From: Damian Sullivan
Sent: 11 September 2014 11:59
To: Andrew Fuller
Subject: RE: CM/30/14/HH - Poole Place, Climping

From: Estella [REDACTED]
Sent: 10 September 2014 12:37
To: Damian Sullivan
Cc: AFA
Subject: CM/30/14/HH - Poole Place, Climping

We would like to substitute a couple of drawings under the above application reference. Please find attached drawings 102A & 105A

East Elevation

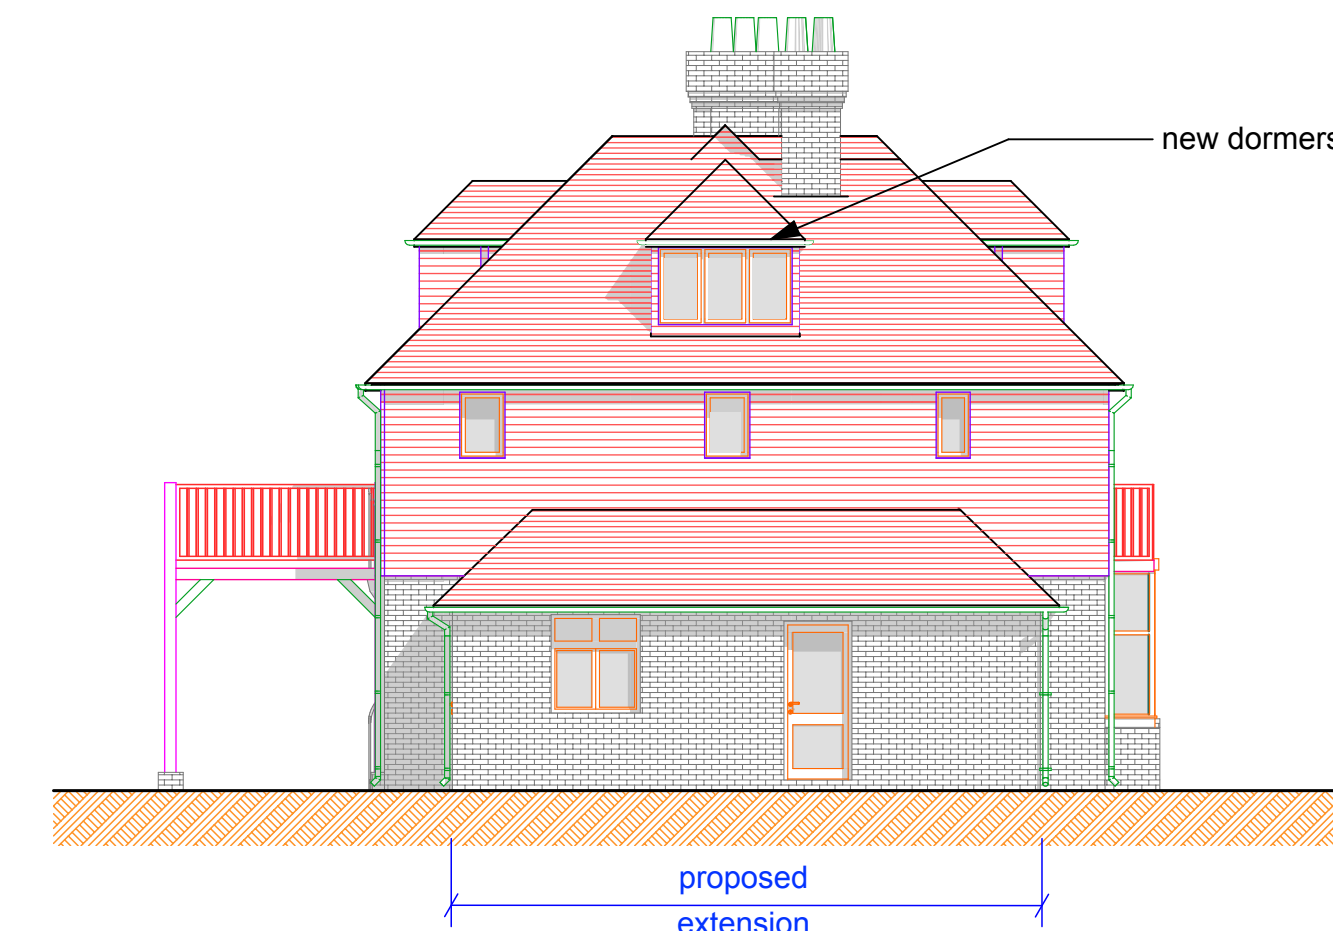
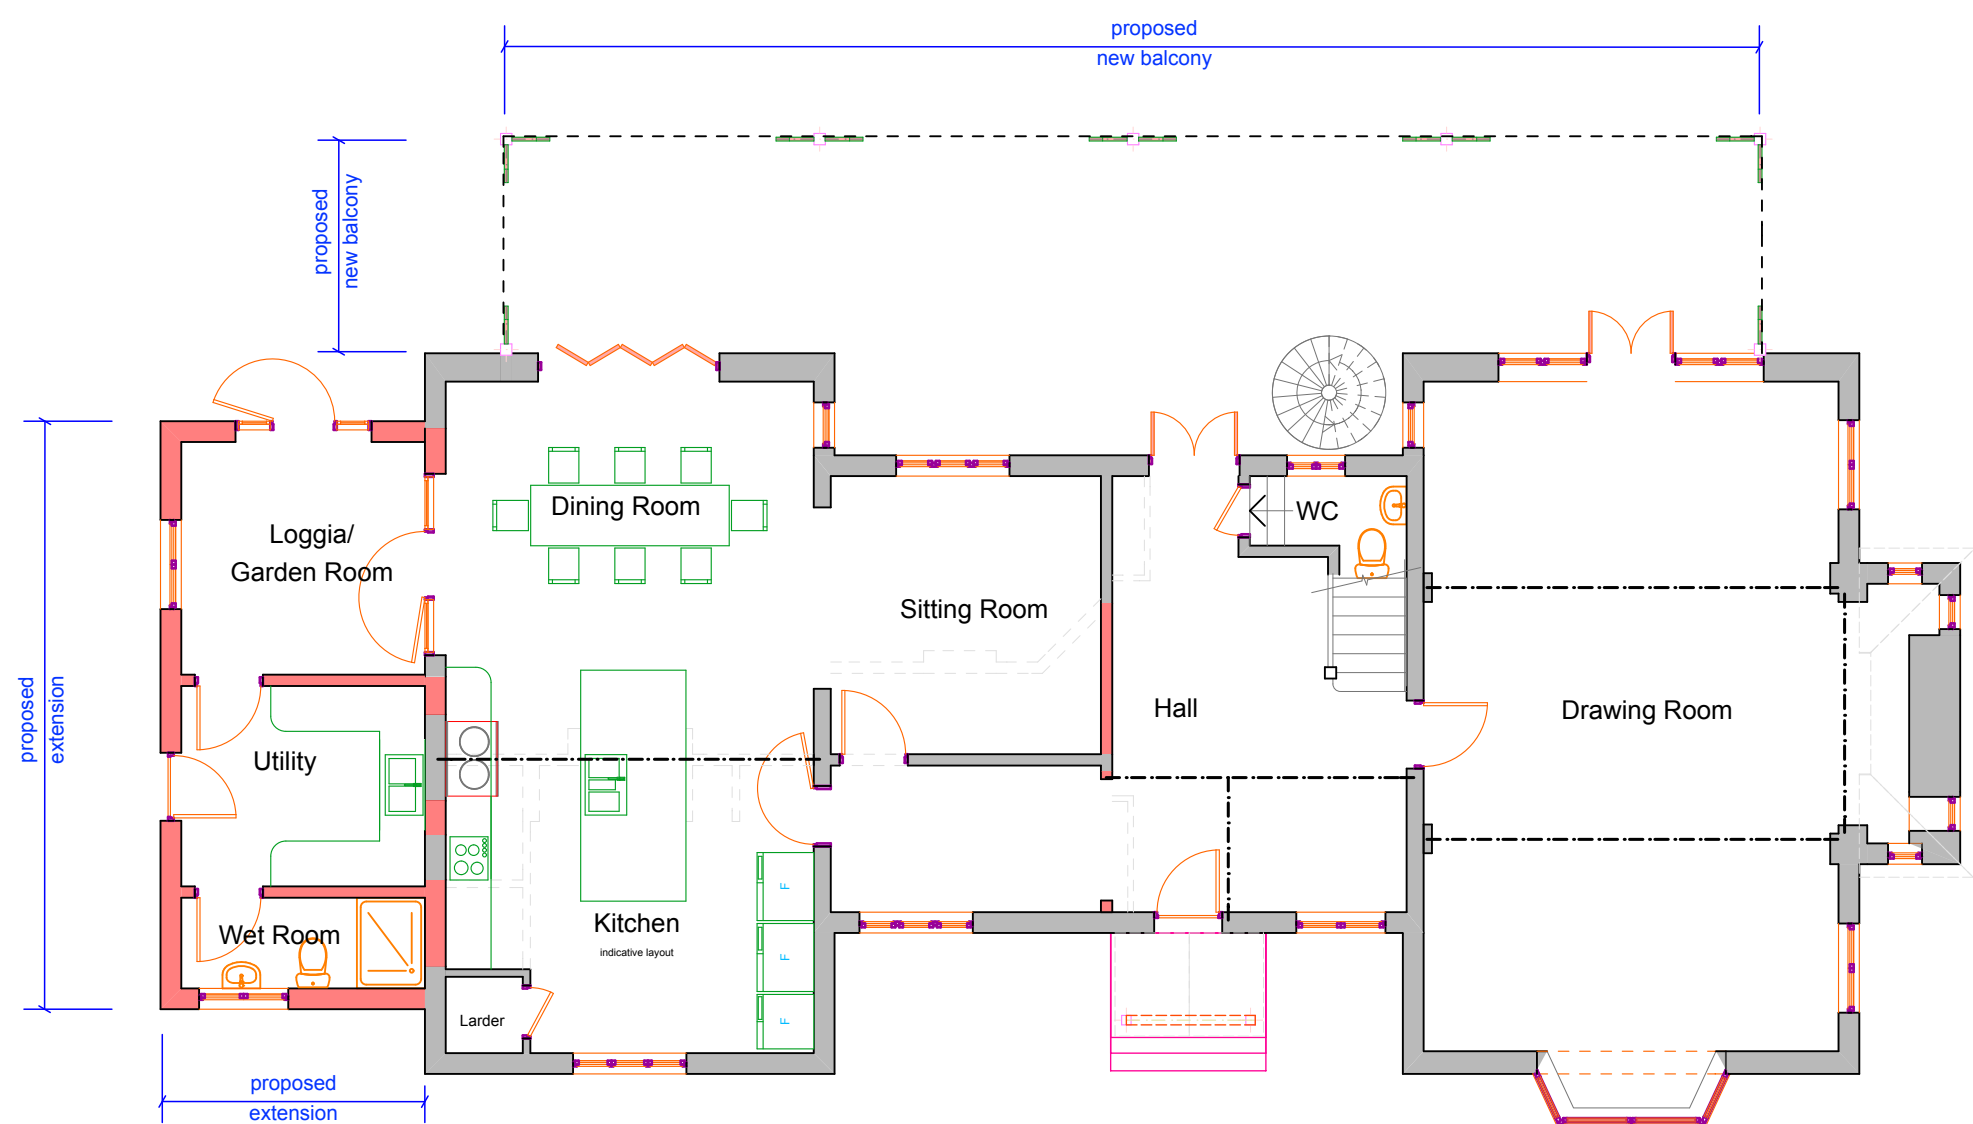
Unfortunately due to the changes being made especially the swimming pool, although even the dormers on the east elevation, mean that these cannot be accepted as substitute drawings as they will require re-advertising. You are of course welcome to withdraw the application and start again with a resubmission at this point.
